P1795 Remondis Tomago RFI August 2021

REMONDIS Australia Pty Ltd

**Proposed resource recovery facility, 21D School Drive, Tomago NSW  
Response to TfNSW RFI dated 23<sup>rd</sup> July 2021**

Location: McIntyre Road at Tomato Road, Tomago

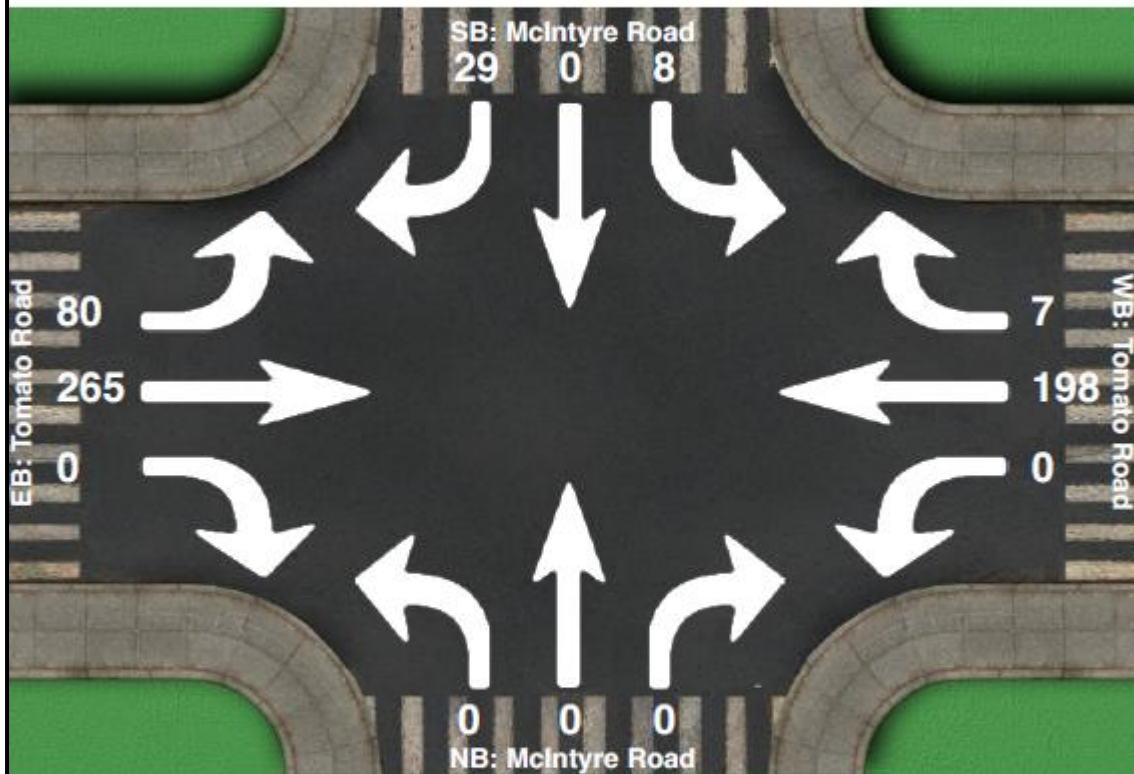
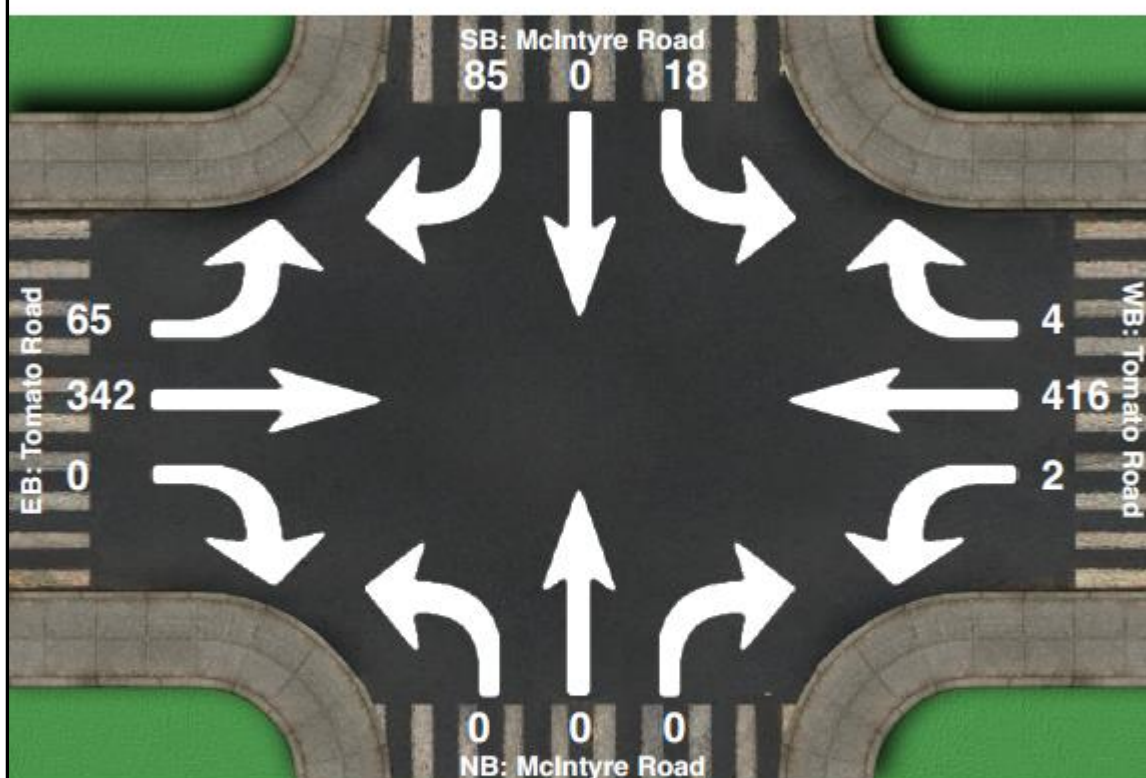
*That the traffic volumes collected are not relevant to understanding the existing traffic environment. The traffic counts for the Tomago Road and McIntyre Road intersection were undertaken on 6 July 2021, which was within the NSW school holiday period. It is considered that the surveyed traffic volumes would unlikely represent typical Tomago Road peak hour traffic volumes.*

The surveys at Tomago Road and McIntyre Road were actually collected on the 6<sup>th</sup> July 2020, not 2021. Notwithstanding this, the date in 2020 was the Monday on the first day of the school holidays in NSW. The surveys were completed at this time, as it was considered that the traffic flows at this location would not be greatly impacted by school traffic. There are no schools within this location that would influence traffic demands associated with school drop off / pick up. Covid restrictions at that time reduced the extent of holiday travel and as such it was considered at that time that the traffic demands at that time were reflective of normal traffic demands in that location.

A further traffic survey has been completed by Seca Solution at this intersection on Thursday 5<sup>th</sup> August 2021. This survey was completed on the Thursday afternoon prior to the commencement of the current lockdown that occurred that day from 5.00 PM. The survey was completed for the corresponding peak hour previously identified in the survey from July 2020. The two sets of survey results are provided below:

Viewing the above survey results, the traffic flows from July 2020 are still considered valid with the traffic flows on Tomago Road being similar eastbound and in fact higher westbound in 2020, which would have a greater impact on the critical right turn out traffic movement from McIntyre Road.

Thus, it is considered that the Sidra modelling completed is valid and represents typical traffic demands at this location, both on Tomago Road and McIntyre Road.
